Subject: R-6 Small Infill Design Review – 30 Merrill Street

Written by: Caitlin Cameron, Urban Designer

Date of Review: Wednesday, October 19, 2016

SHEET TITLE
2ND 3RD FLOOR

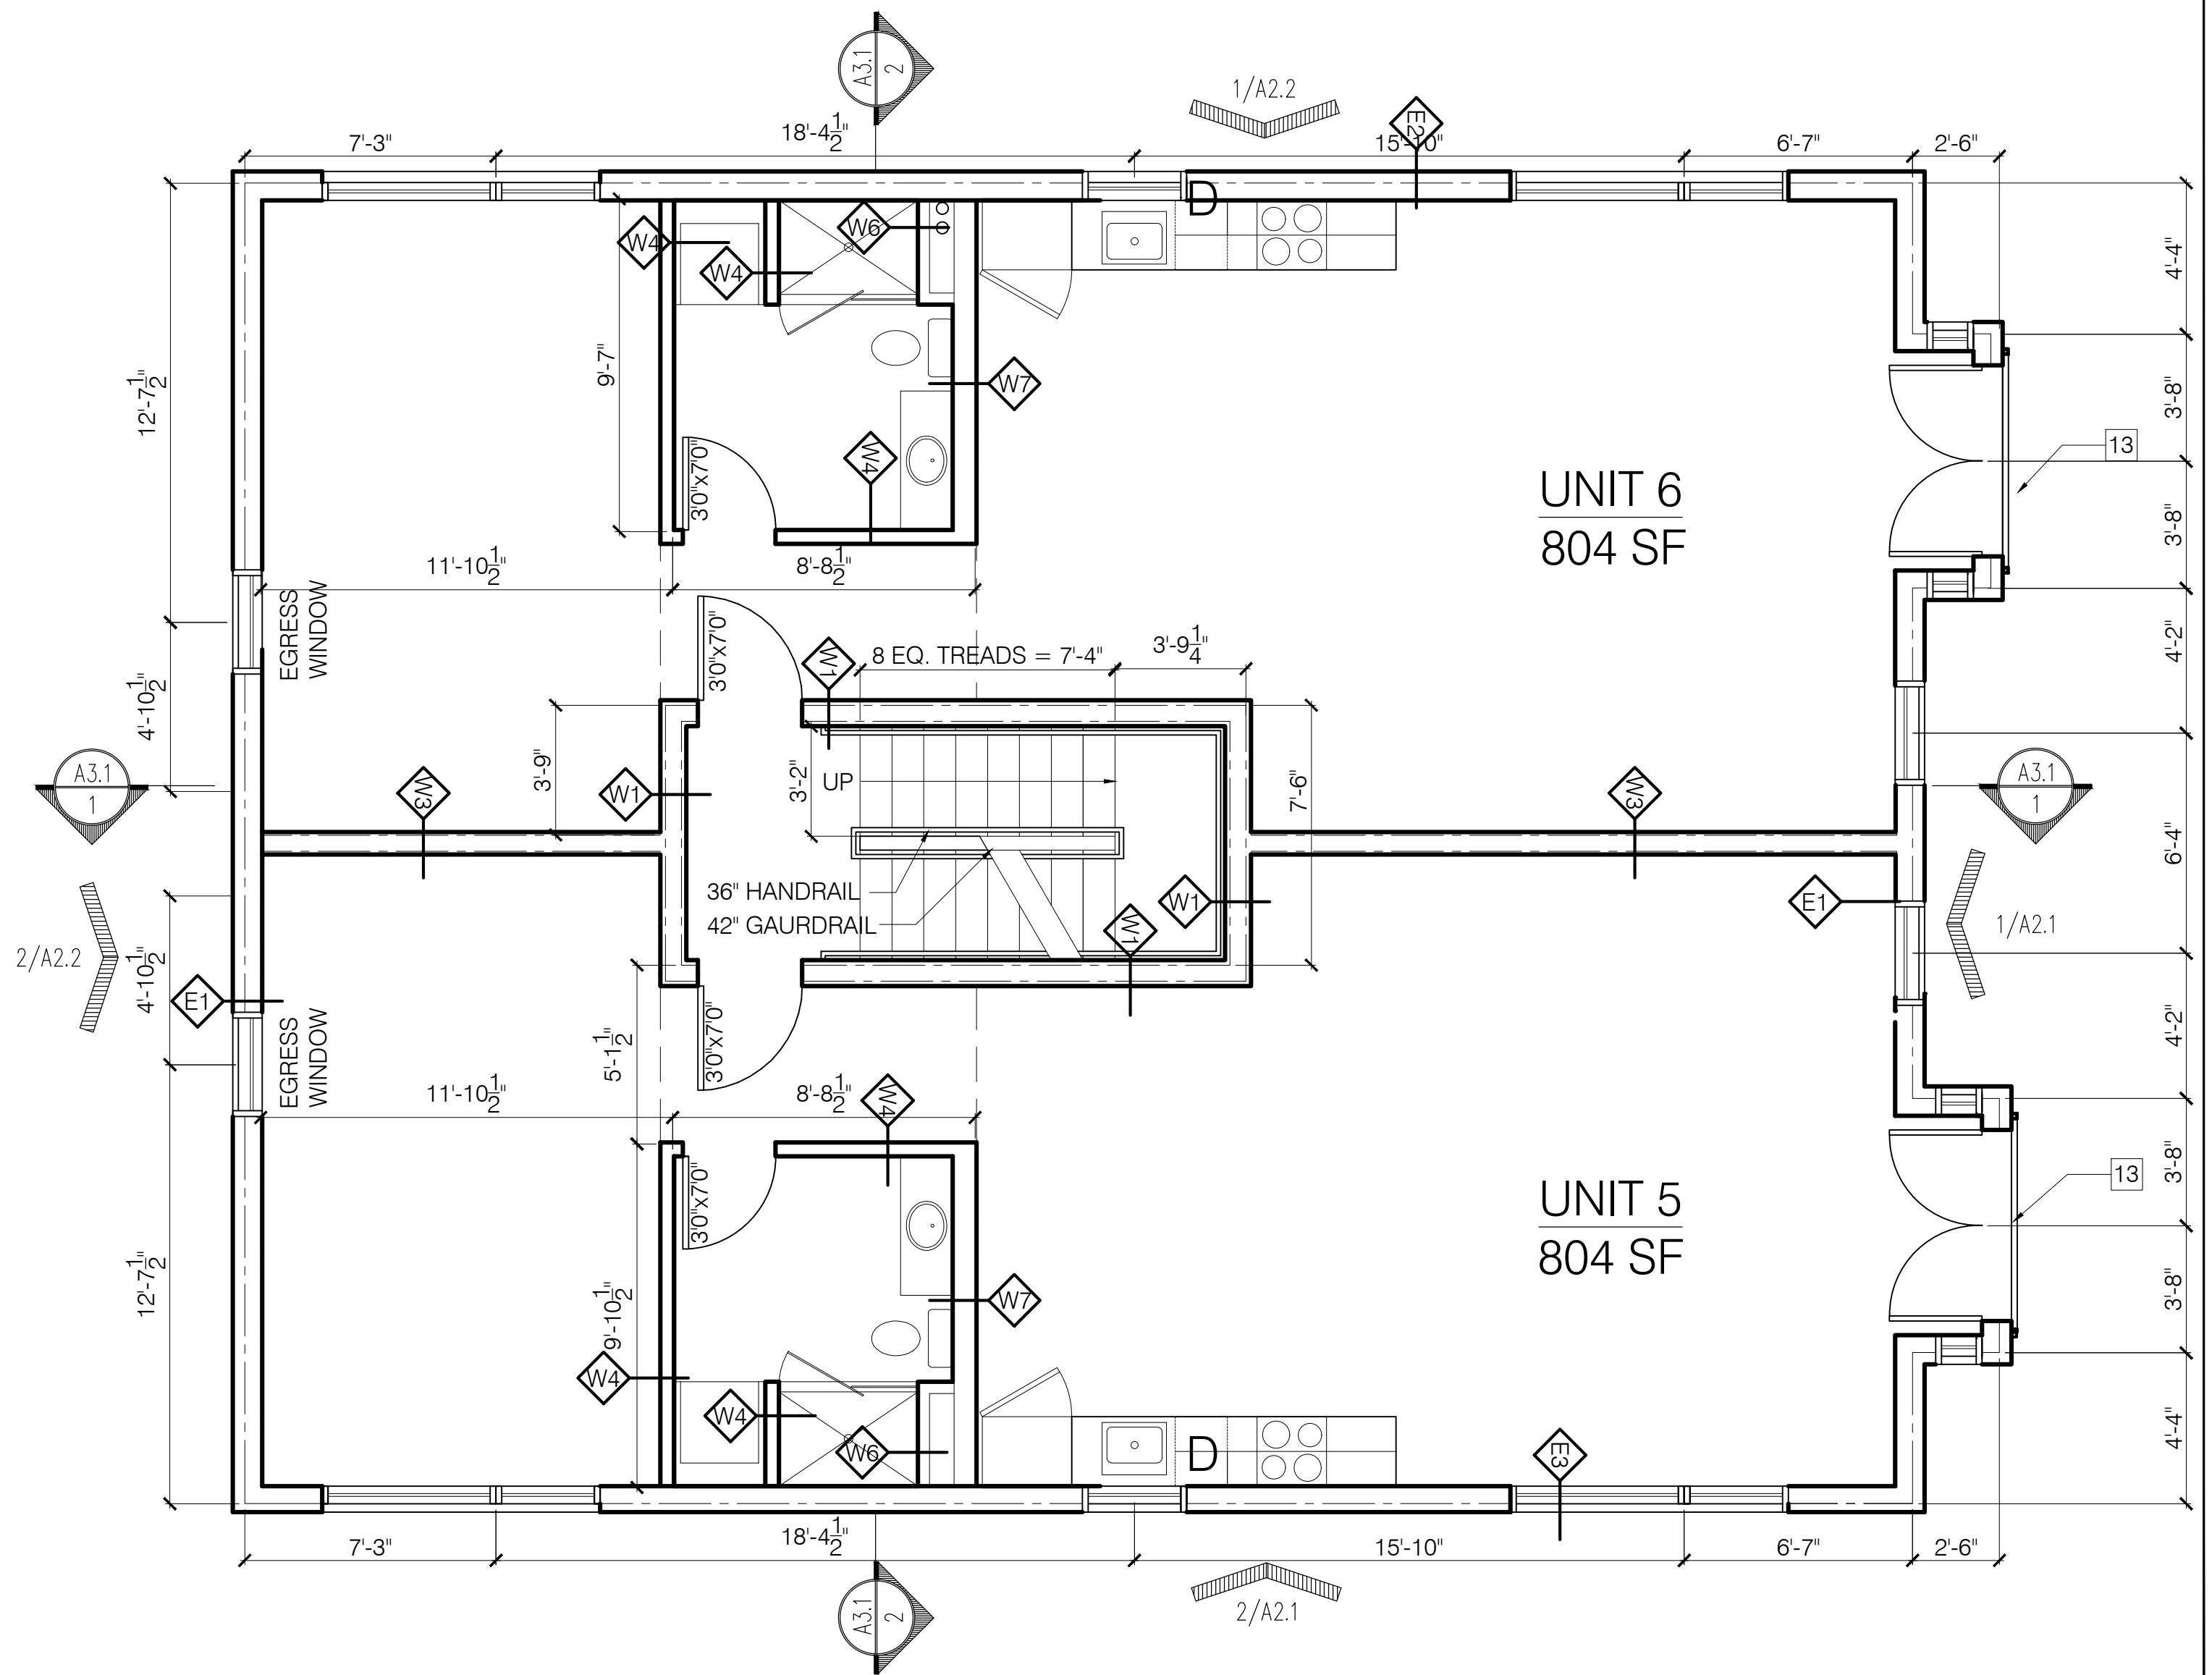
- *A-2 Composition of Principal Facades:* The composition of the street-facing facades is consistent with context in terms of using symmetrical bays (in this case, four bays) that are oriented to the street. The windows were revised to be of similar proportion with those found in the streetscape. The windows in the bays are sliding doors and therefore of a different type than the traditional bay window. Staff found that the bays and the balconies bring articulation, vertical proportion, and human scale to the large windows.

- *D-1 Windows:* The majority of windows are rectangular and have vertical proportion; windows at bays are sliding doors and therefore taller than traditional bay windows.
- *D-2 Fenestration:* The project appears to meet the 12% fenestration requirement and appropriately scaled to the massing of the building.
- *D-3 Porches:* The balconies included in this project are less than 48 sf and do not meet this standard.

- *E-1 Window and Door Height:* The majority of window and door head heights align along a common horizontal datum.
- *E-2 Window and Door Alignment:* The majority of windows shall stack so that centerlines of windows are in vertical alignment.
- *E-3 Symmetry:* Primary window compositions are arranged symmetrically around discernable vertical axes.

3 FOURTH FLOOR  
SCALE: 1/4" = 1'-0"

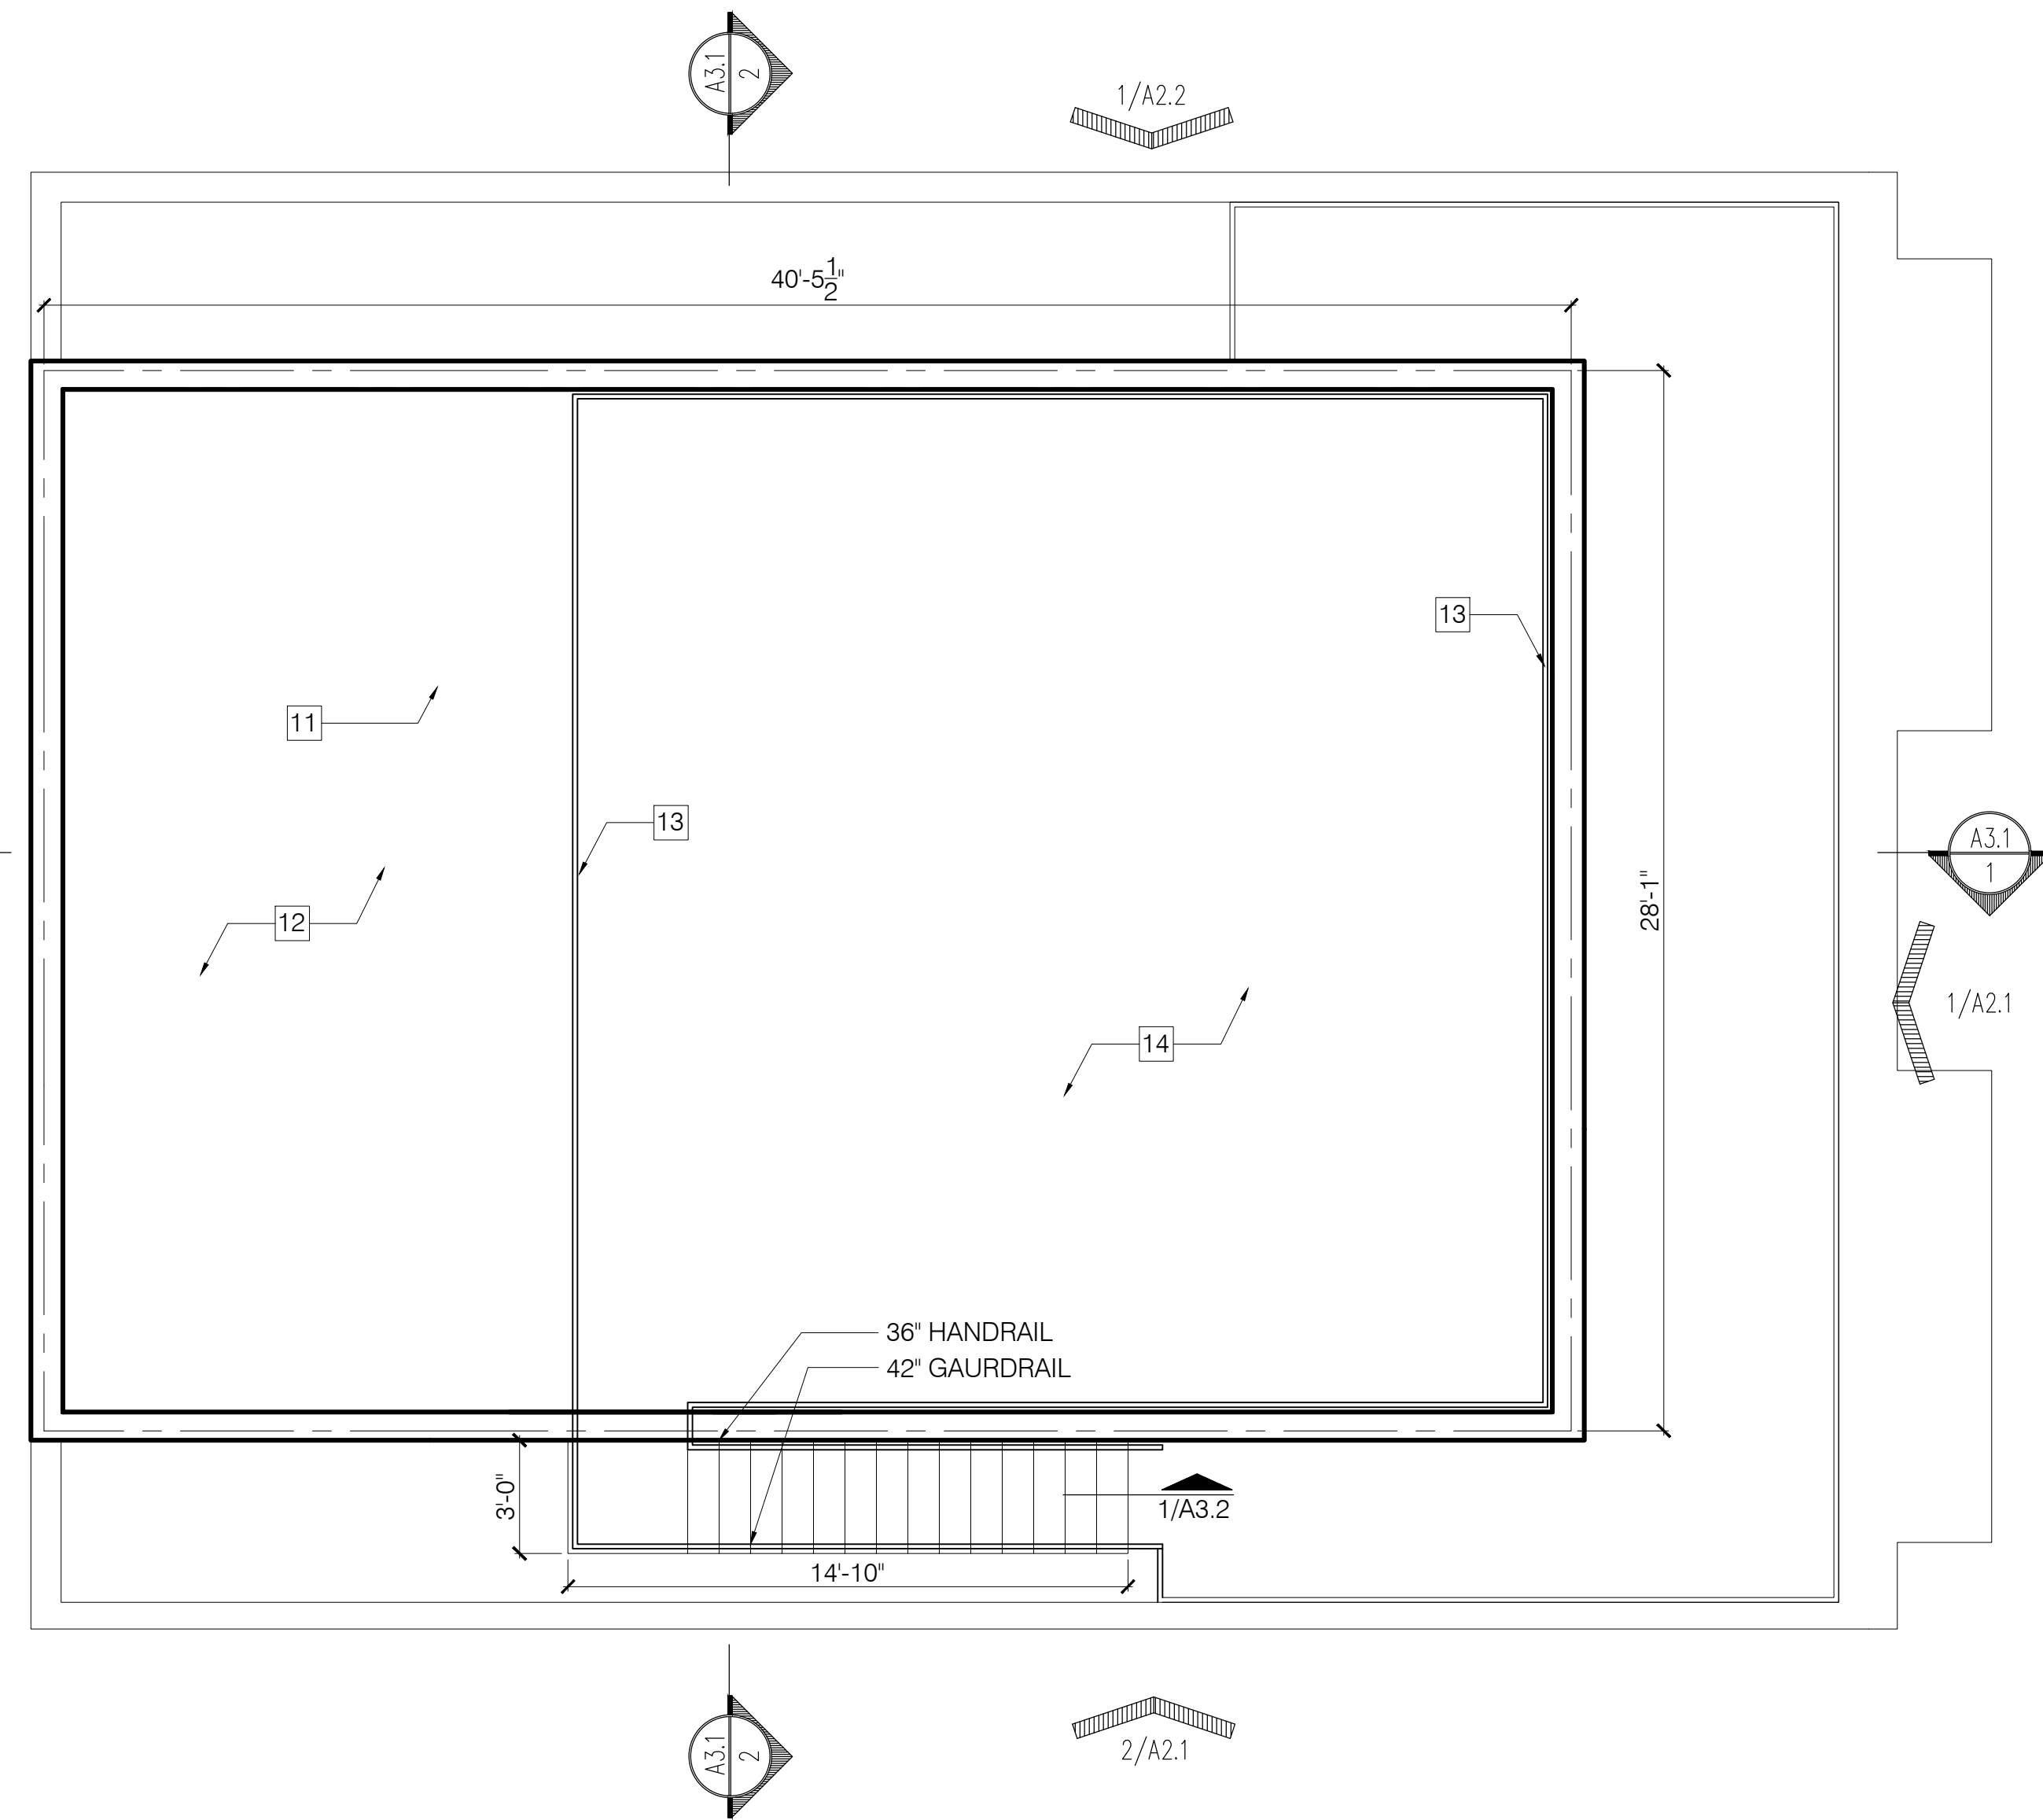
- *A-1 Scale and Form:* The building type proposed is similar to a double-triple with an additional unit on the 4th floor. Double-triples can be found in the surrounding context, however, the scale and form of those buildings are mitigated with the use of mansard or other similar roof forms on the third floor, pronounced and overhang cornice lines, bay windows, recessed entries with canopies. Of these formal and scaling elements, the project employs a canopy at the entrance, recessed entry, overhanging cornice at the third floor, and window bays. The fourth floor is made recessive to emphasize the contextual three-story massing of the main portion of the building relating more directly in scale and form with the triple-decker across the street.

- *B-1 Massing:* The principal mass is reminiscent of a double triple-decker found in the context – revisions to the cornice line at the third floor, the stepback of the fourth floor unit help to emphasize that three-story contextual massing. Bay windows were added to provide a façade plane change.
- *B-2 Roof Forms:* The proposed 7th unit on the top floor has been centered and stepped back with a material change – these three actions make that fourth floor recessive and the flat roof form of the primary mass is dominant.
- *B-4 Roof Pitch:* The roofs are monopitch/ flat roofs.
- *B-5 Façade Articulation:* The project employs three of the required articulation elements – covered entry, recessed entry, and bay windows. Small balconies are also used.
- *B-6 Garages:* Not applicable.
